Subject: Exhibition - Upper South Creek Advanced Water Recycling Centre (SSI-8609189) – NPWS and EPBC Act World Heritage Properties (s12 and 15A) and National Heritage Places (s15B and 15C)

Attachment 1 – EES comments on the Upper South Creek Advanced Water Recycling Centre (SSI-8609189) EIS and technical reports – NPWS reserves and World Heritage properties

**Figure 2.12 Site map**

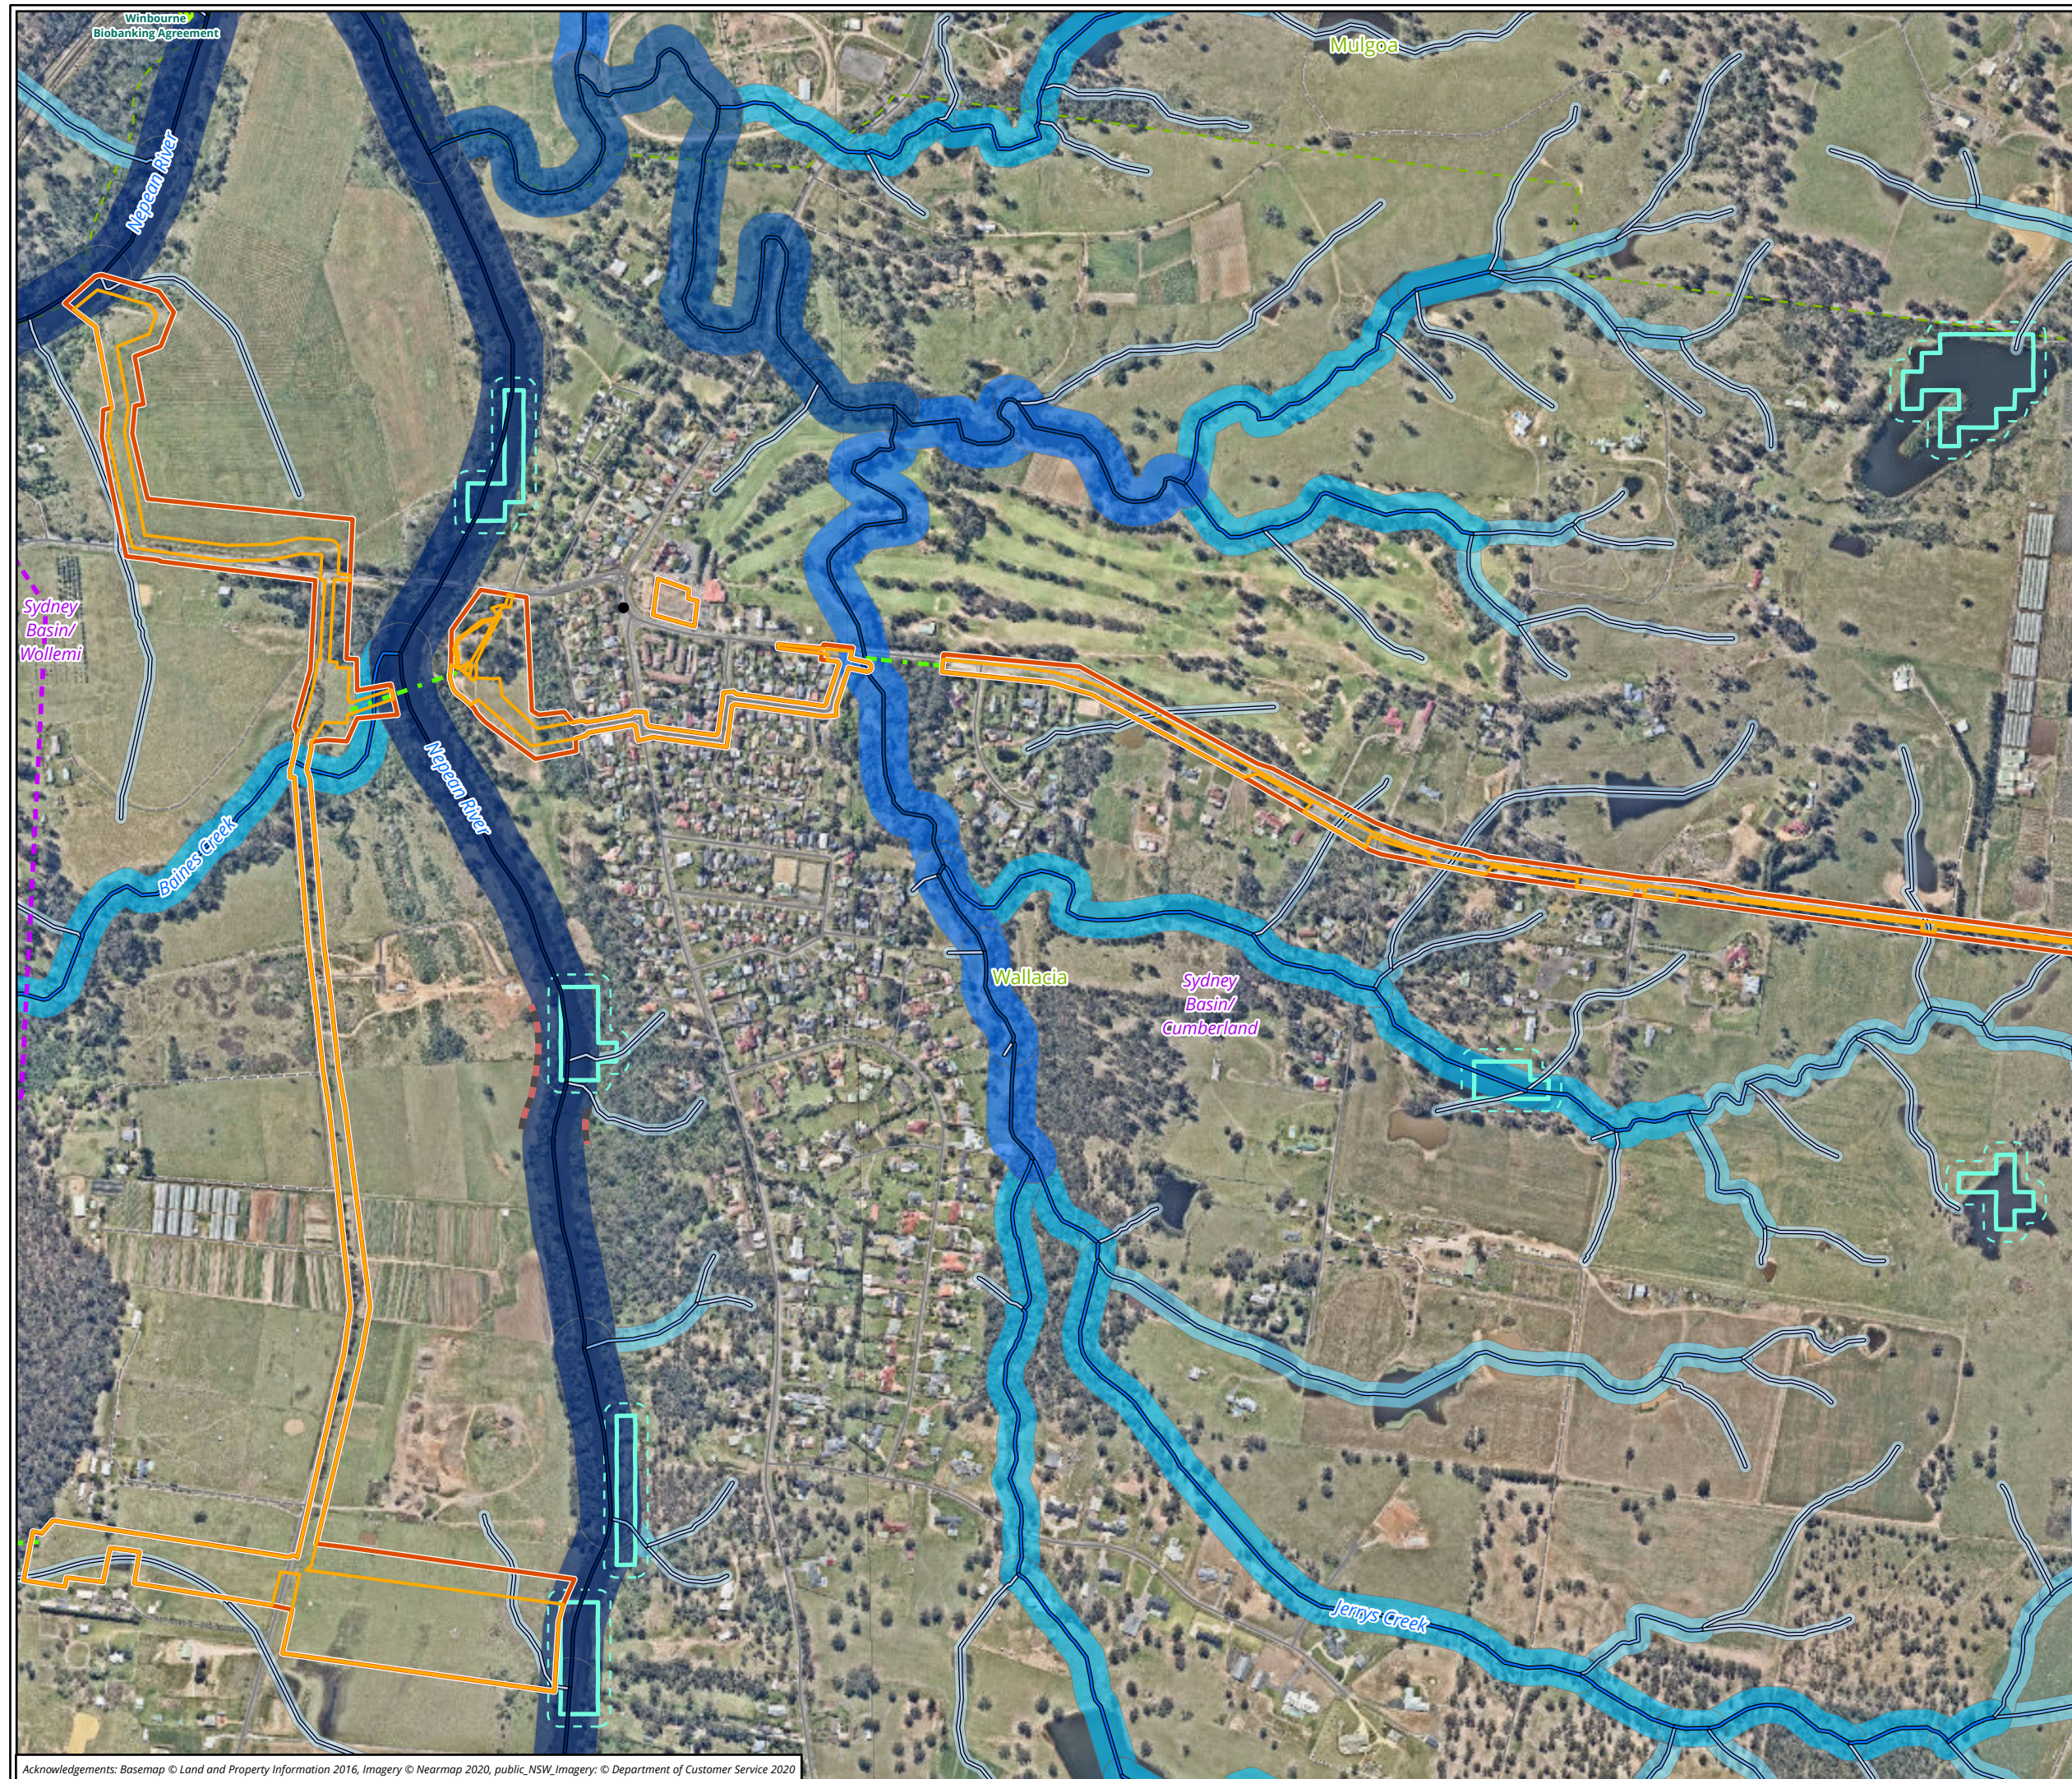
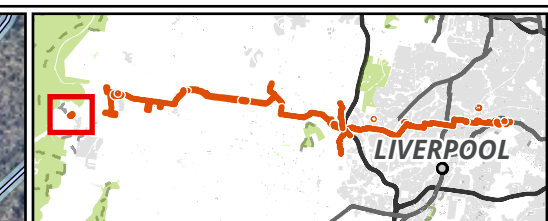
Figures 2.12 and 2.13 of Appendix J Biodiversity Assessment (pp. 22-23) show that the areas downstream of the release points and subject to impact from inundation were not included in the “impact assessment area” and not considered to be part of the “impact area”. As identified in the EIS raised water levels have the potential to impact biodiversity adjacent the rivers, however this potential impact does not appear to have been captured in the Biodiversity Assessment.
